CITY OF ALBUQUERQUE

April 6, 2023

Re: Montage 7
Tracts A-1-A-5-C Mesa del sol Innovation Park
Traffic Circulation Layout
Engineer's Stamp 03-13-23 (R16-D100A)

INTERSECTION CLEAR SIGHT TRIANGLE DETAIL

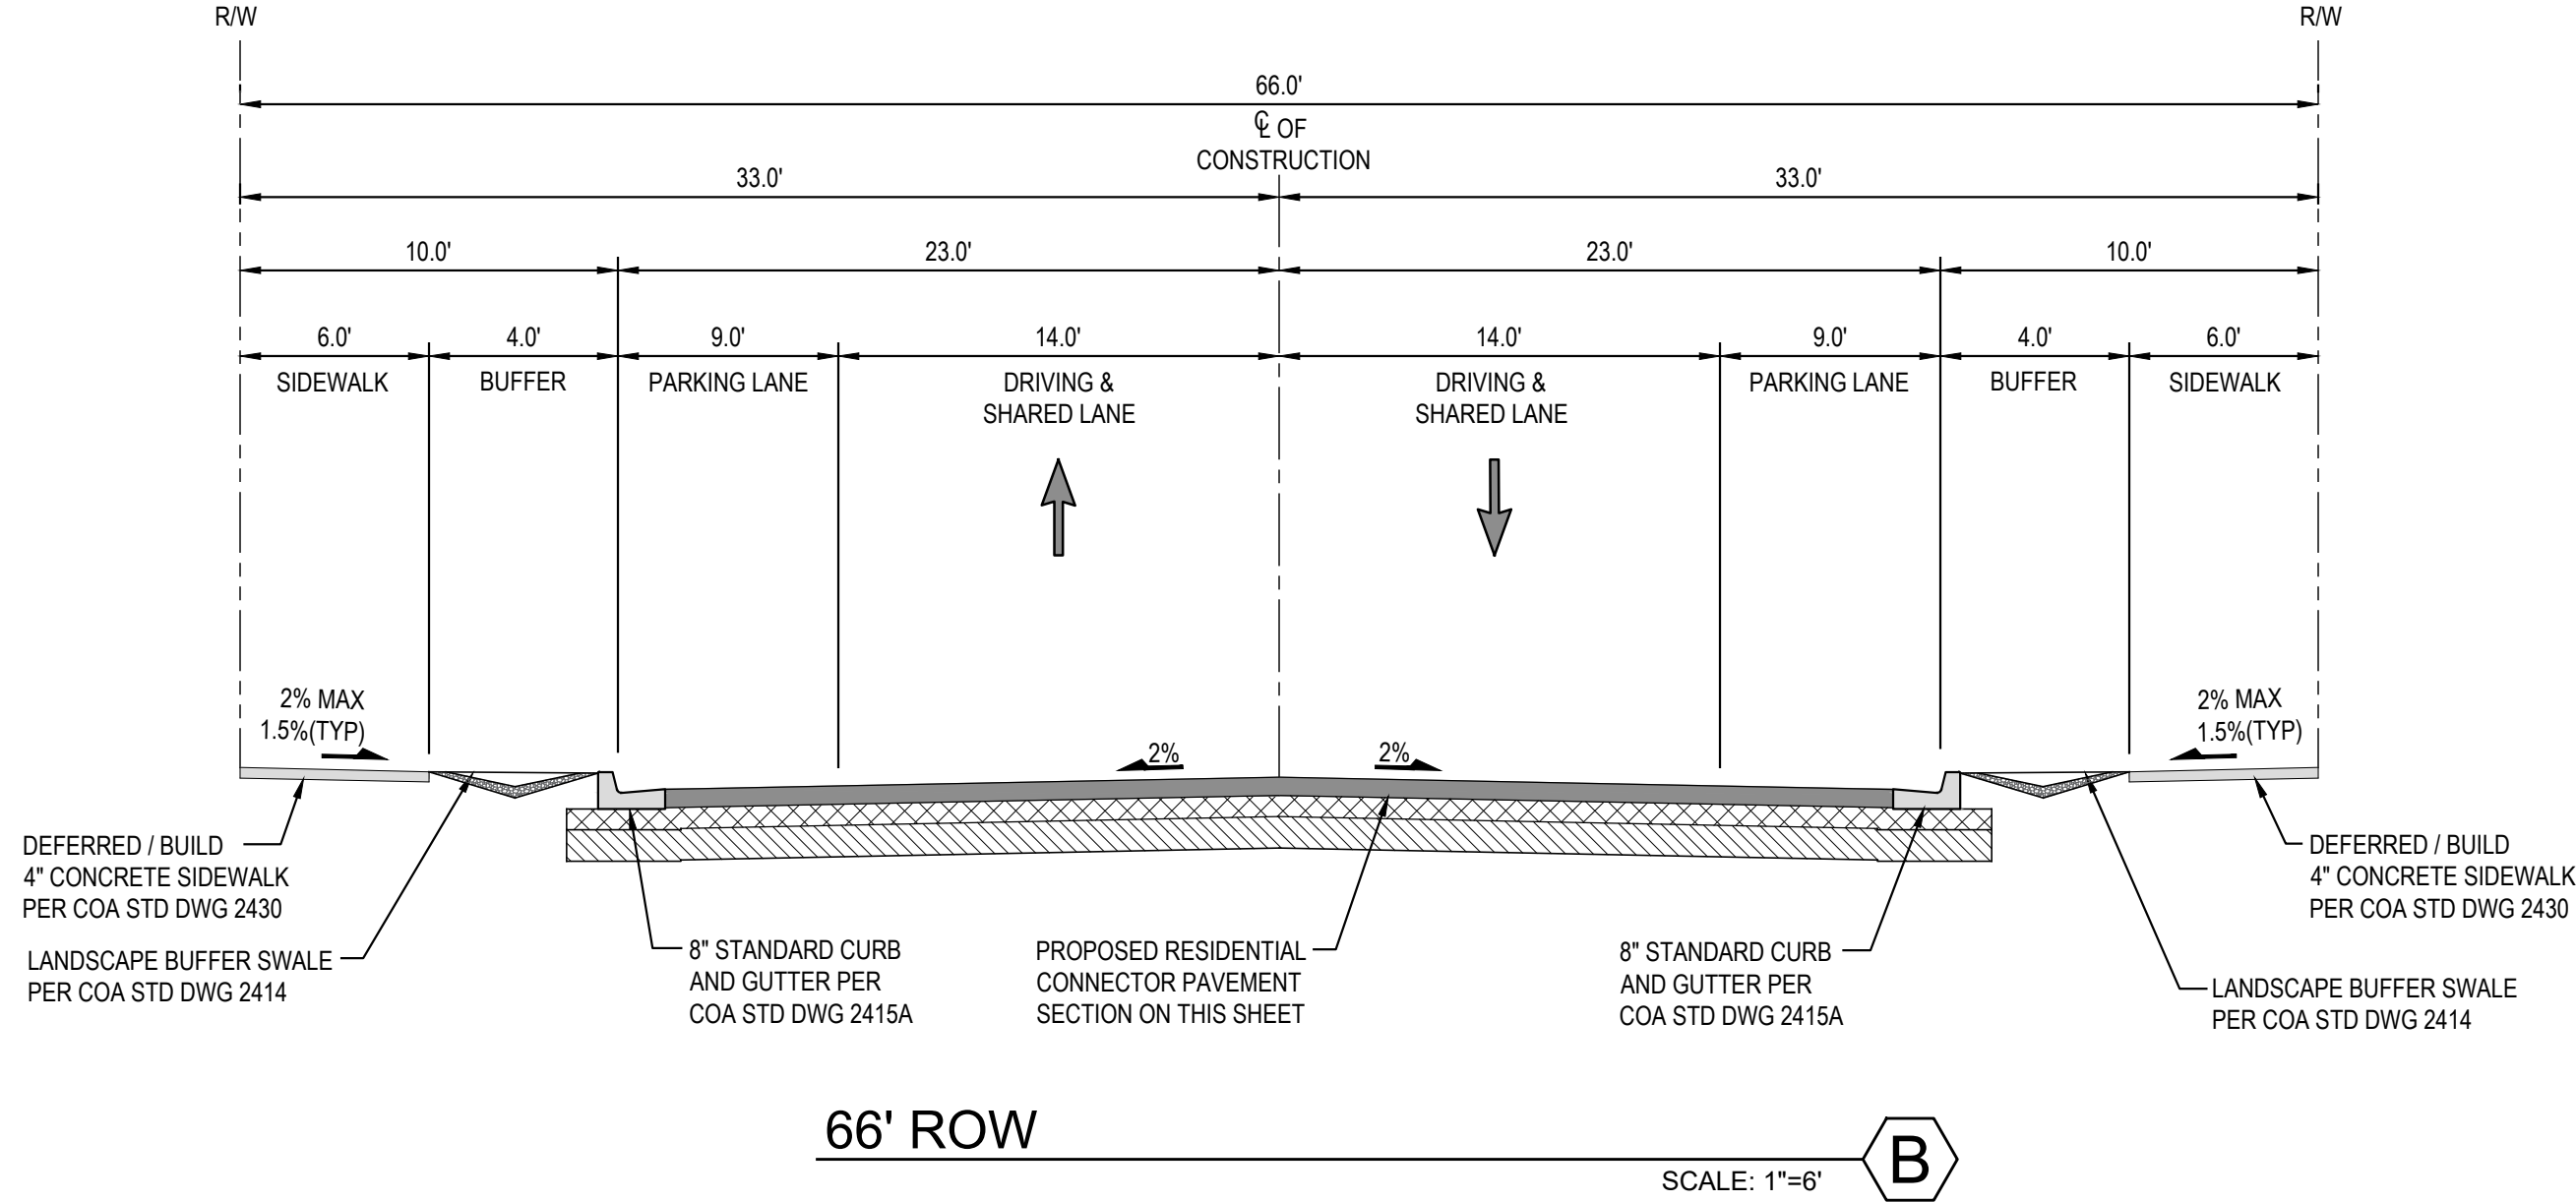
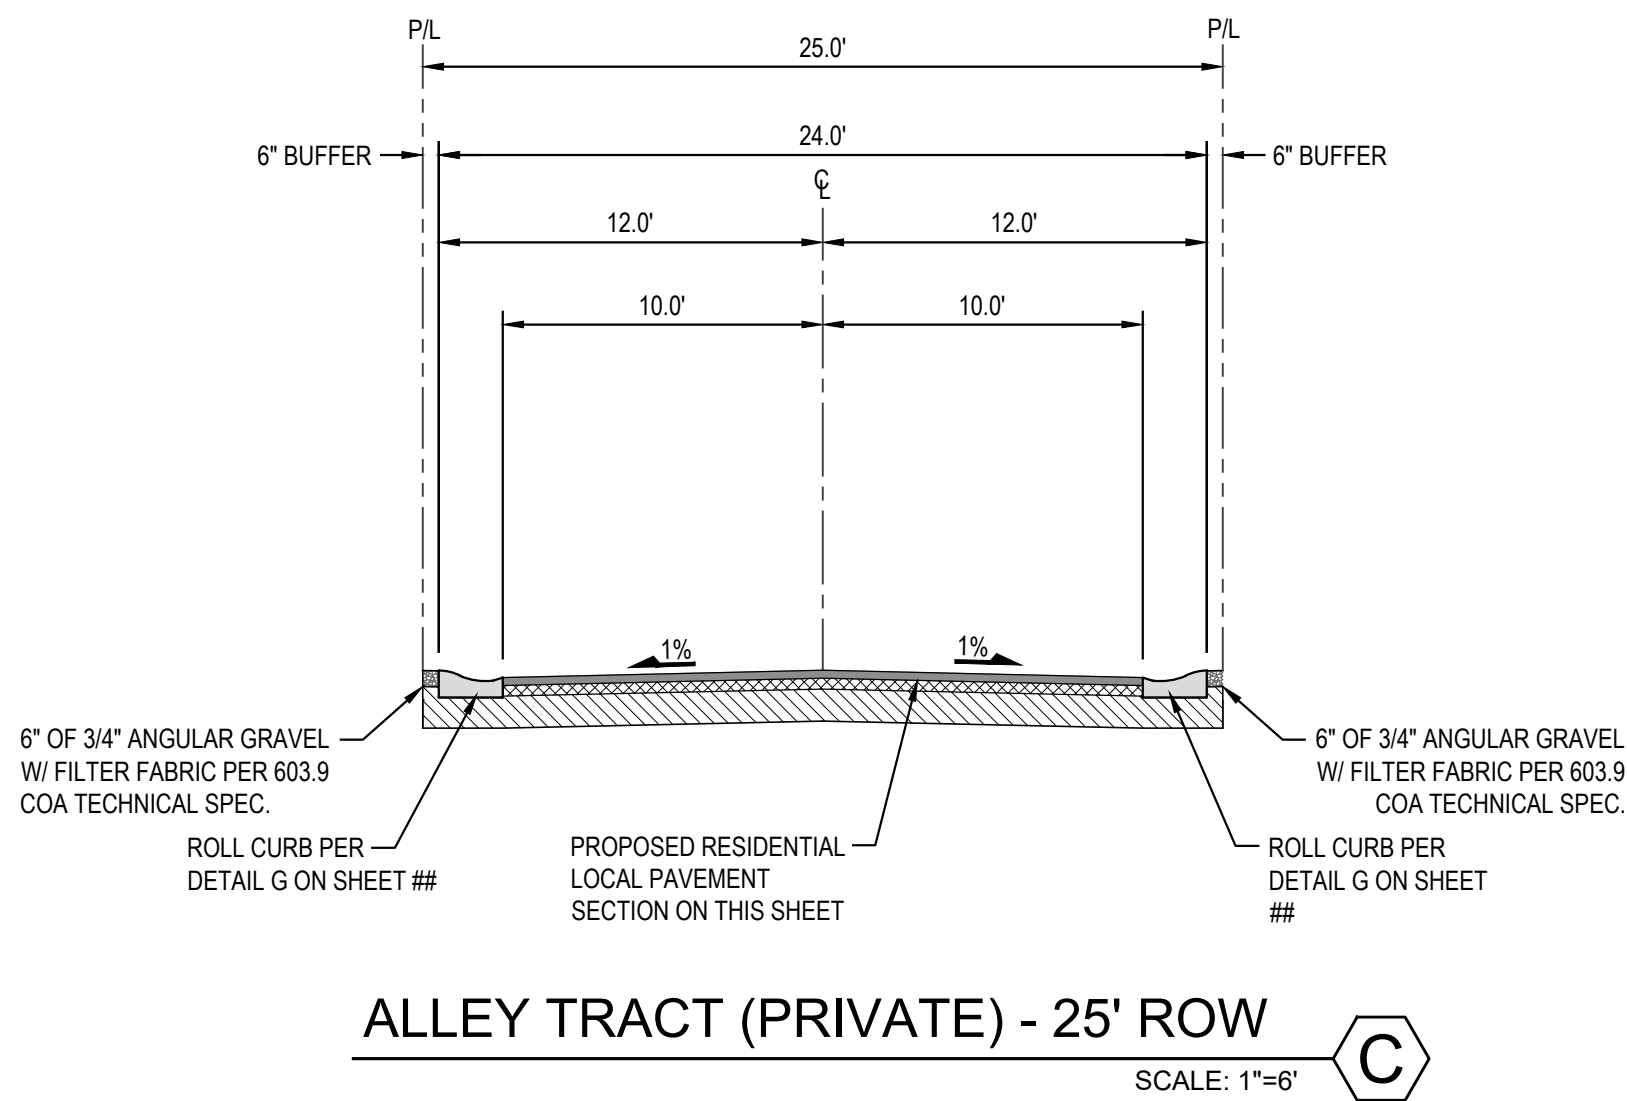
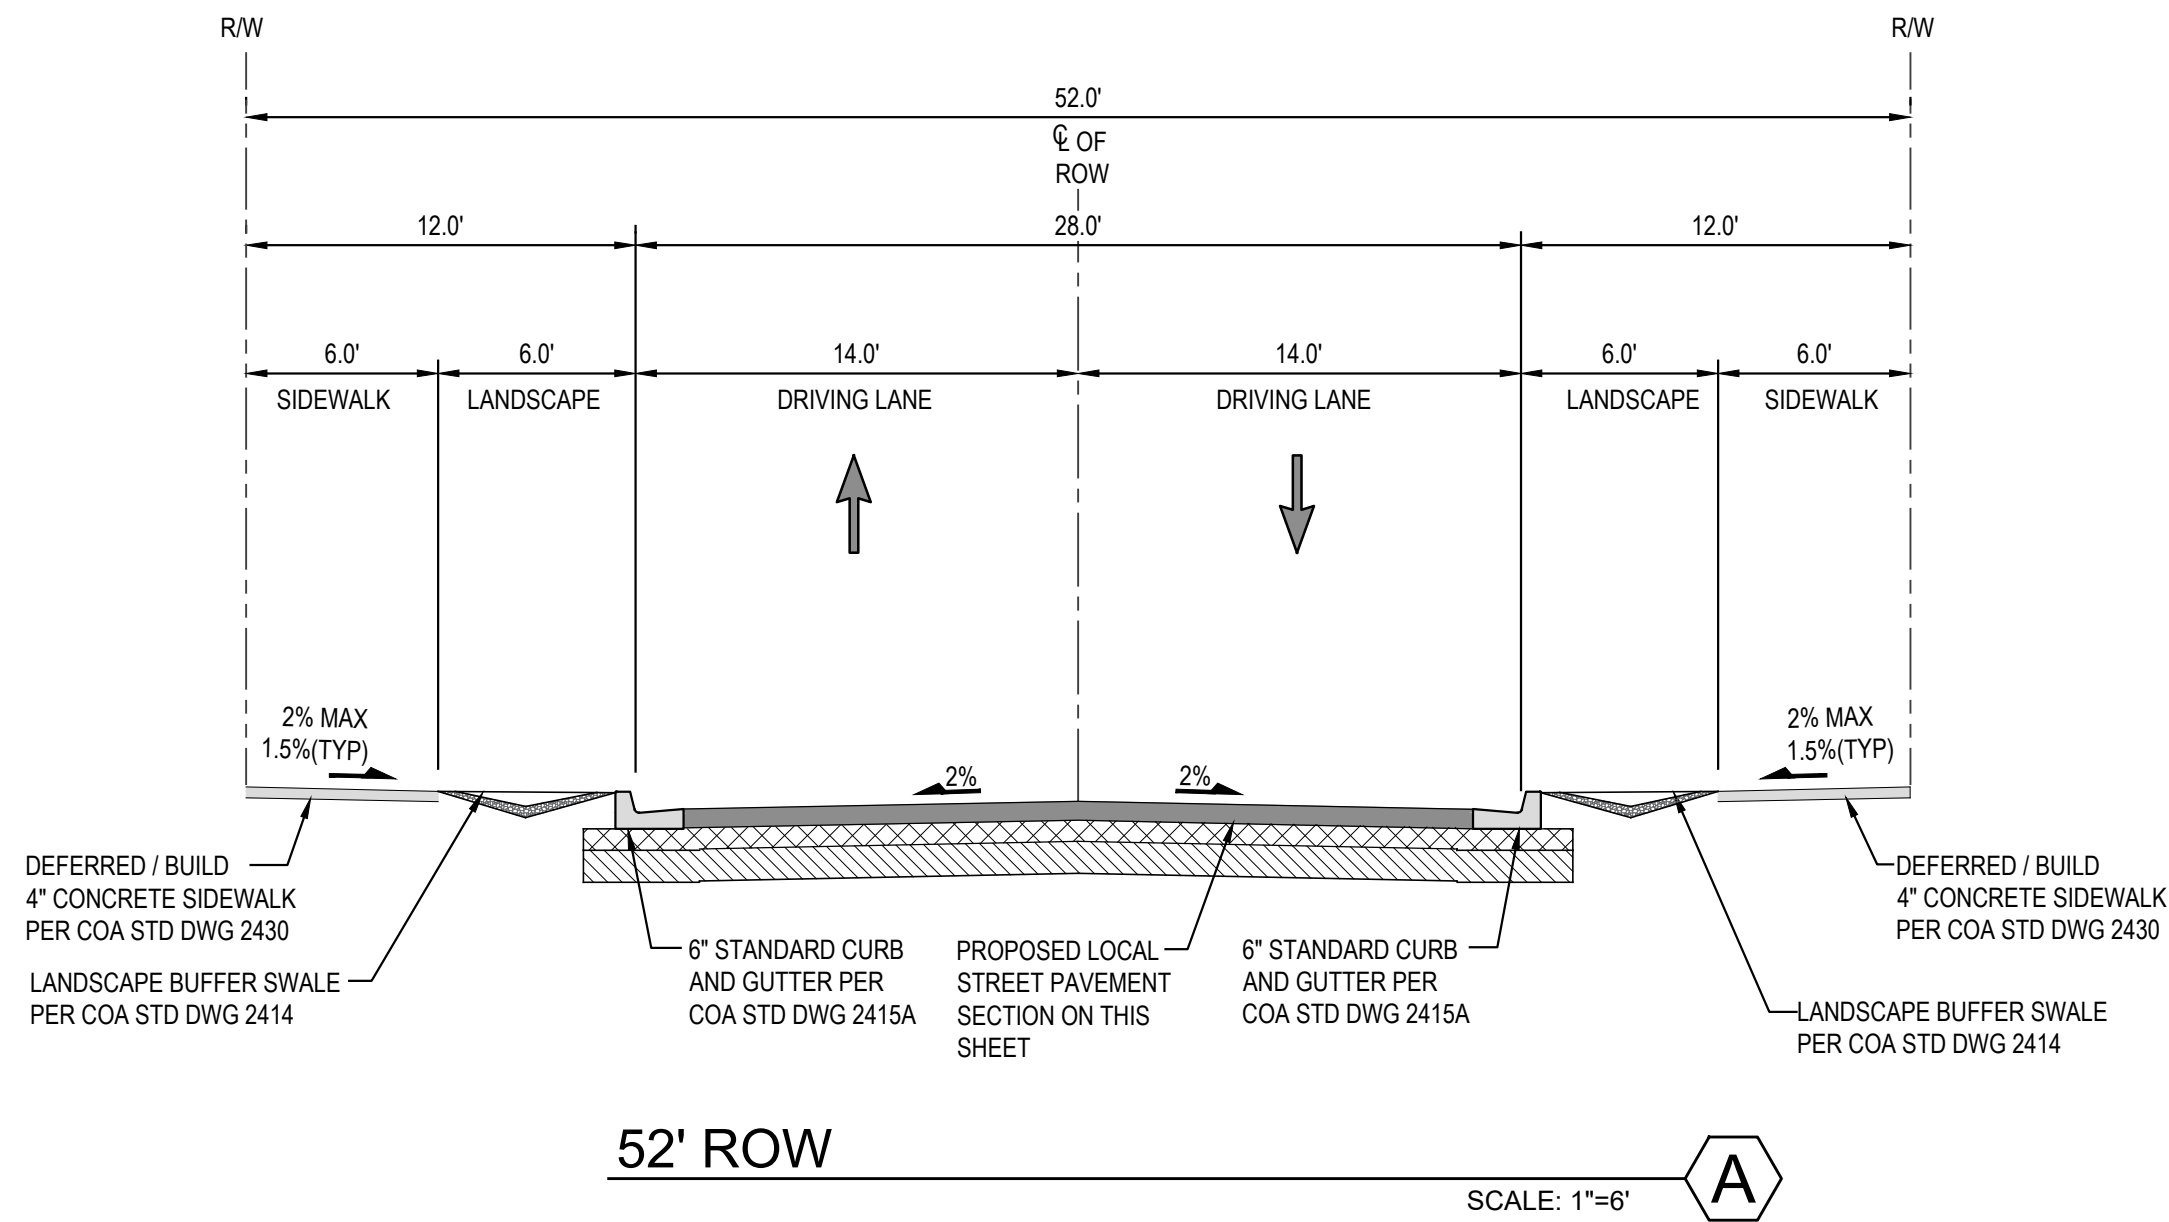
8. Please show on the site plan the Intersection clear sight triangle at the four corners of the site, and on the site access off Sagan Loop.
9. Show the clear sight triangle at the site access off Newhall Dr.
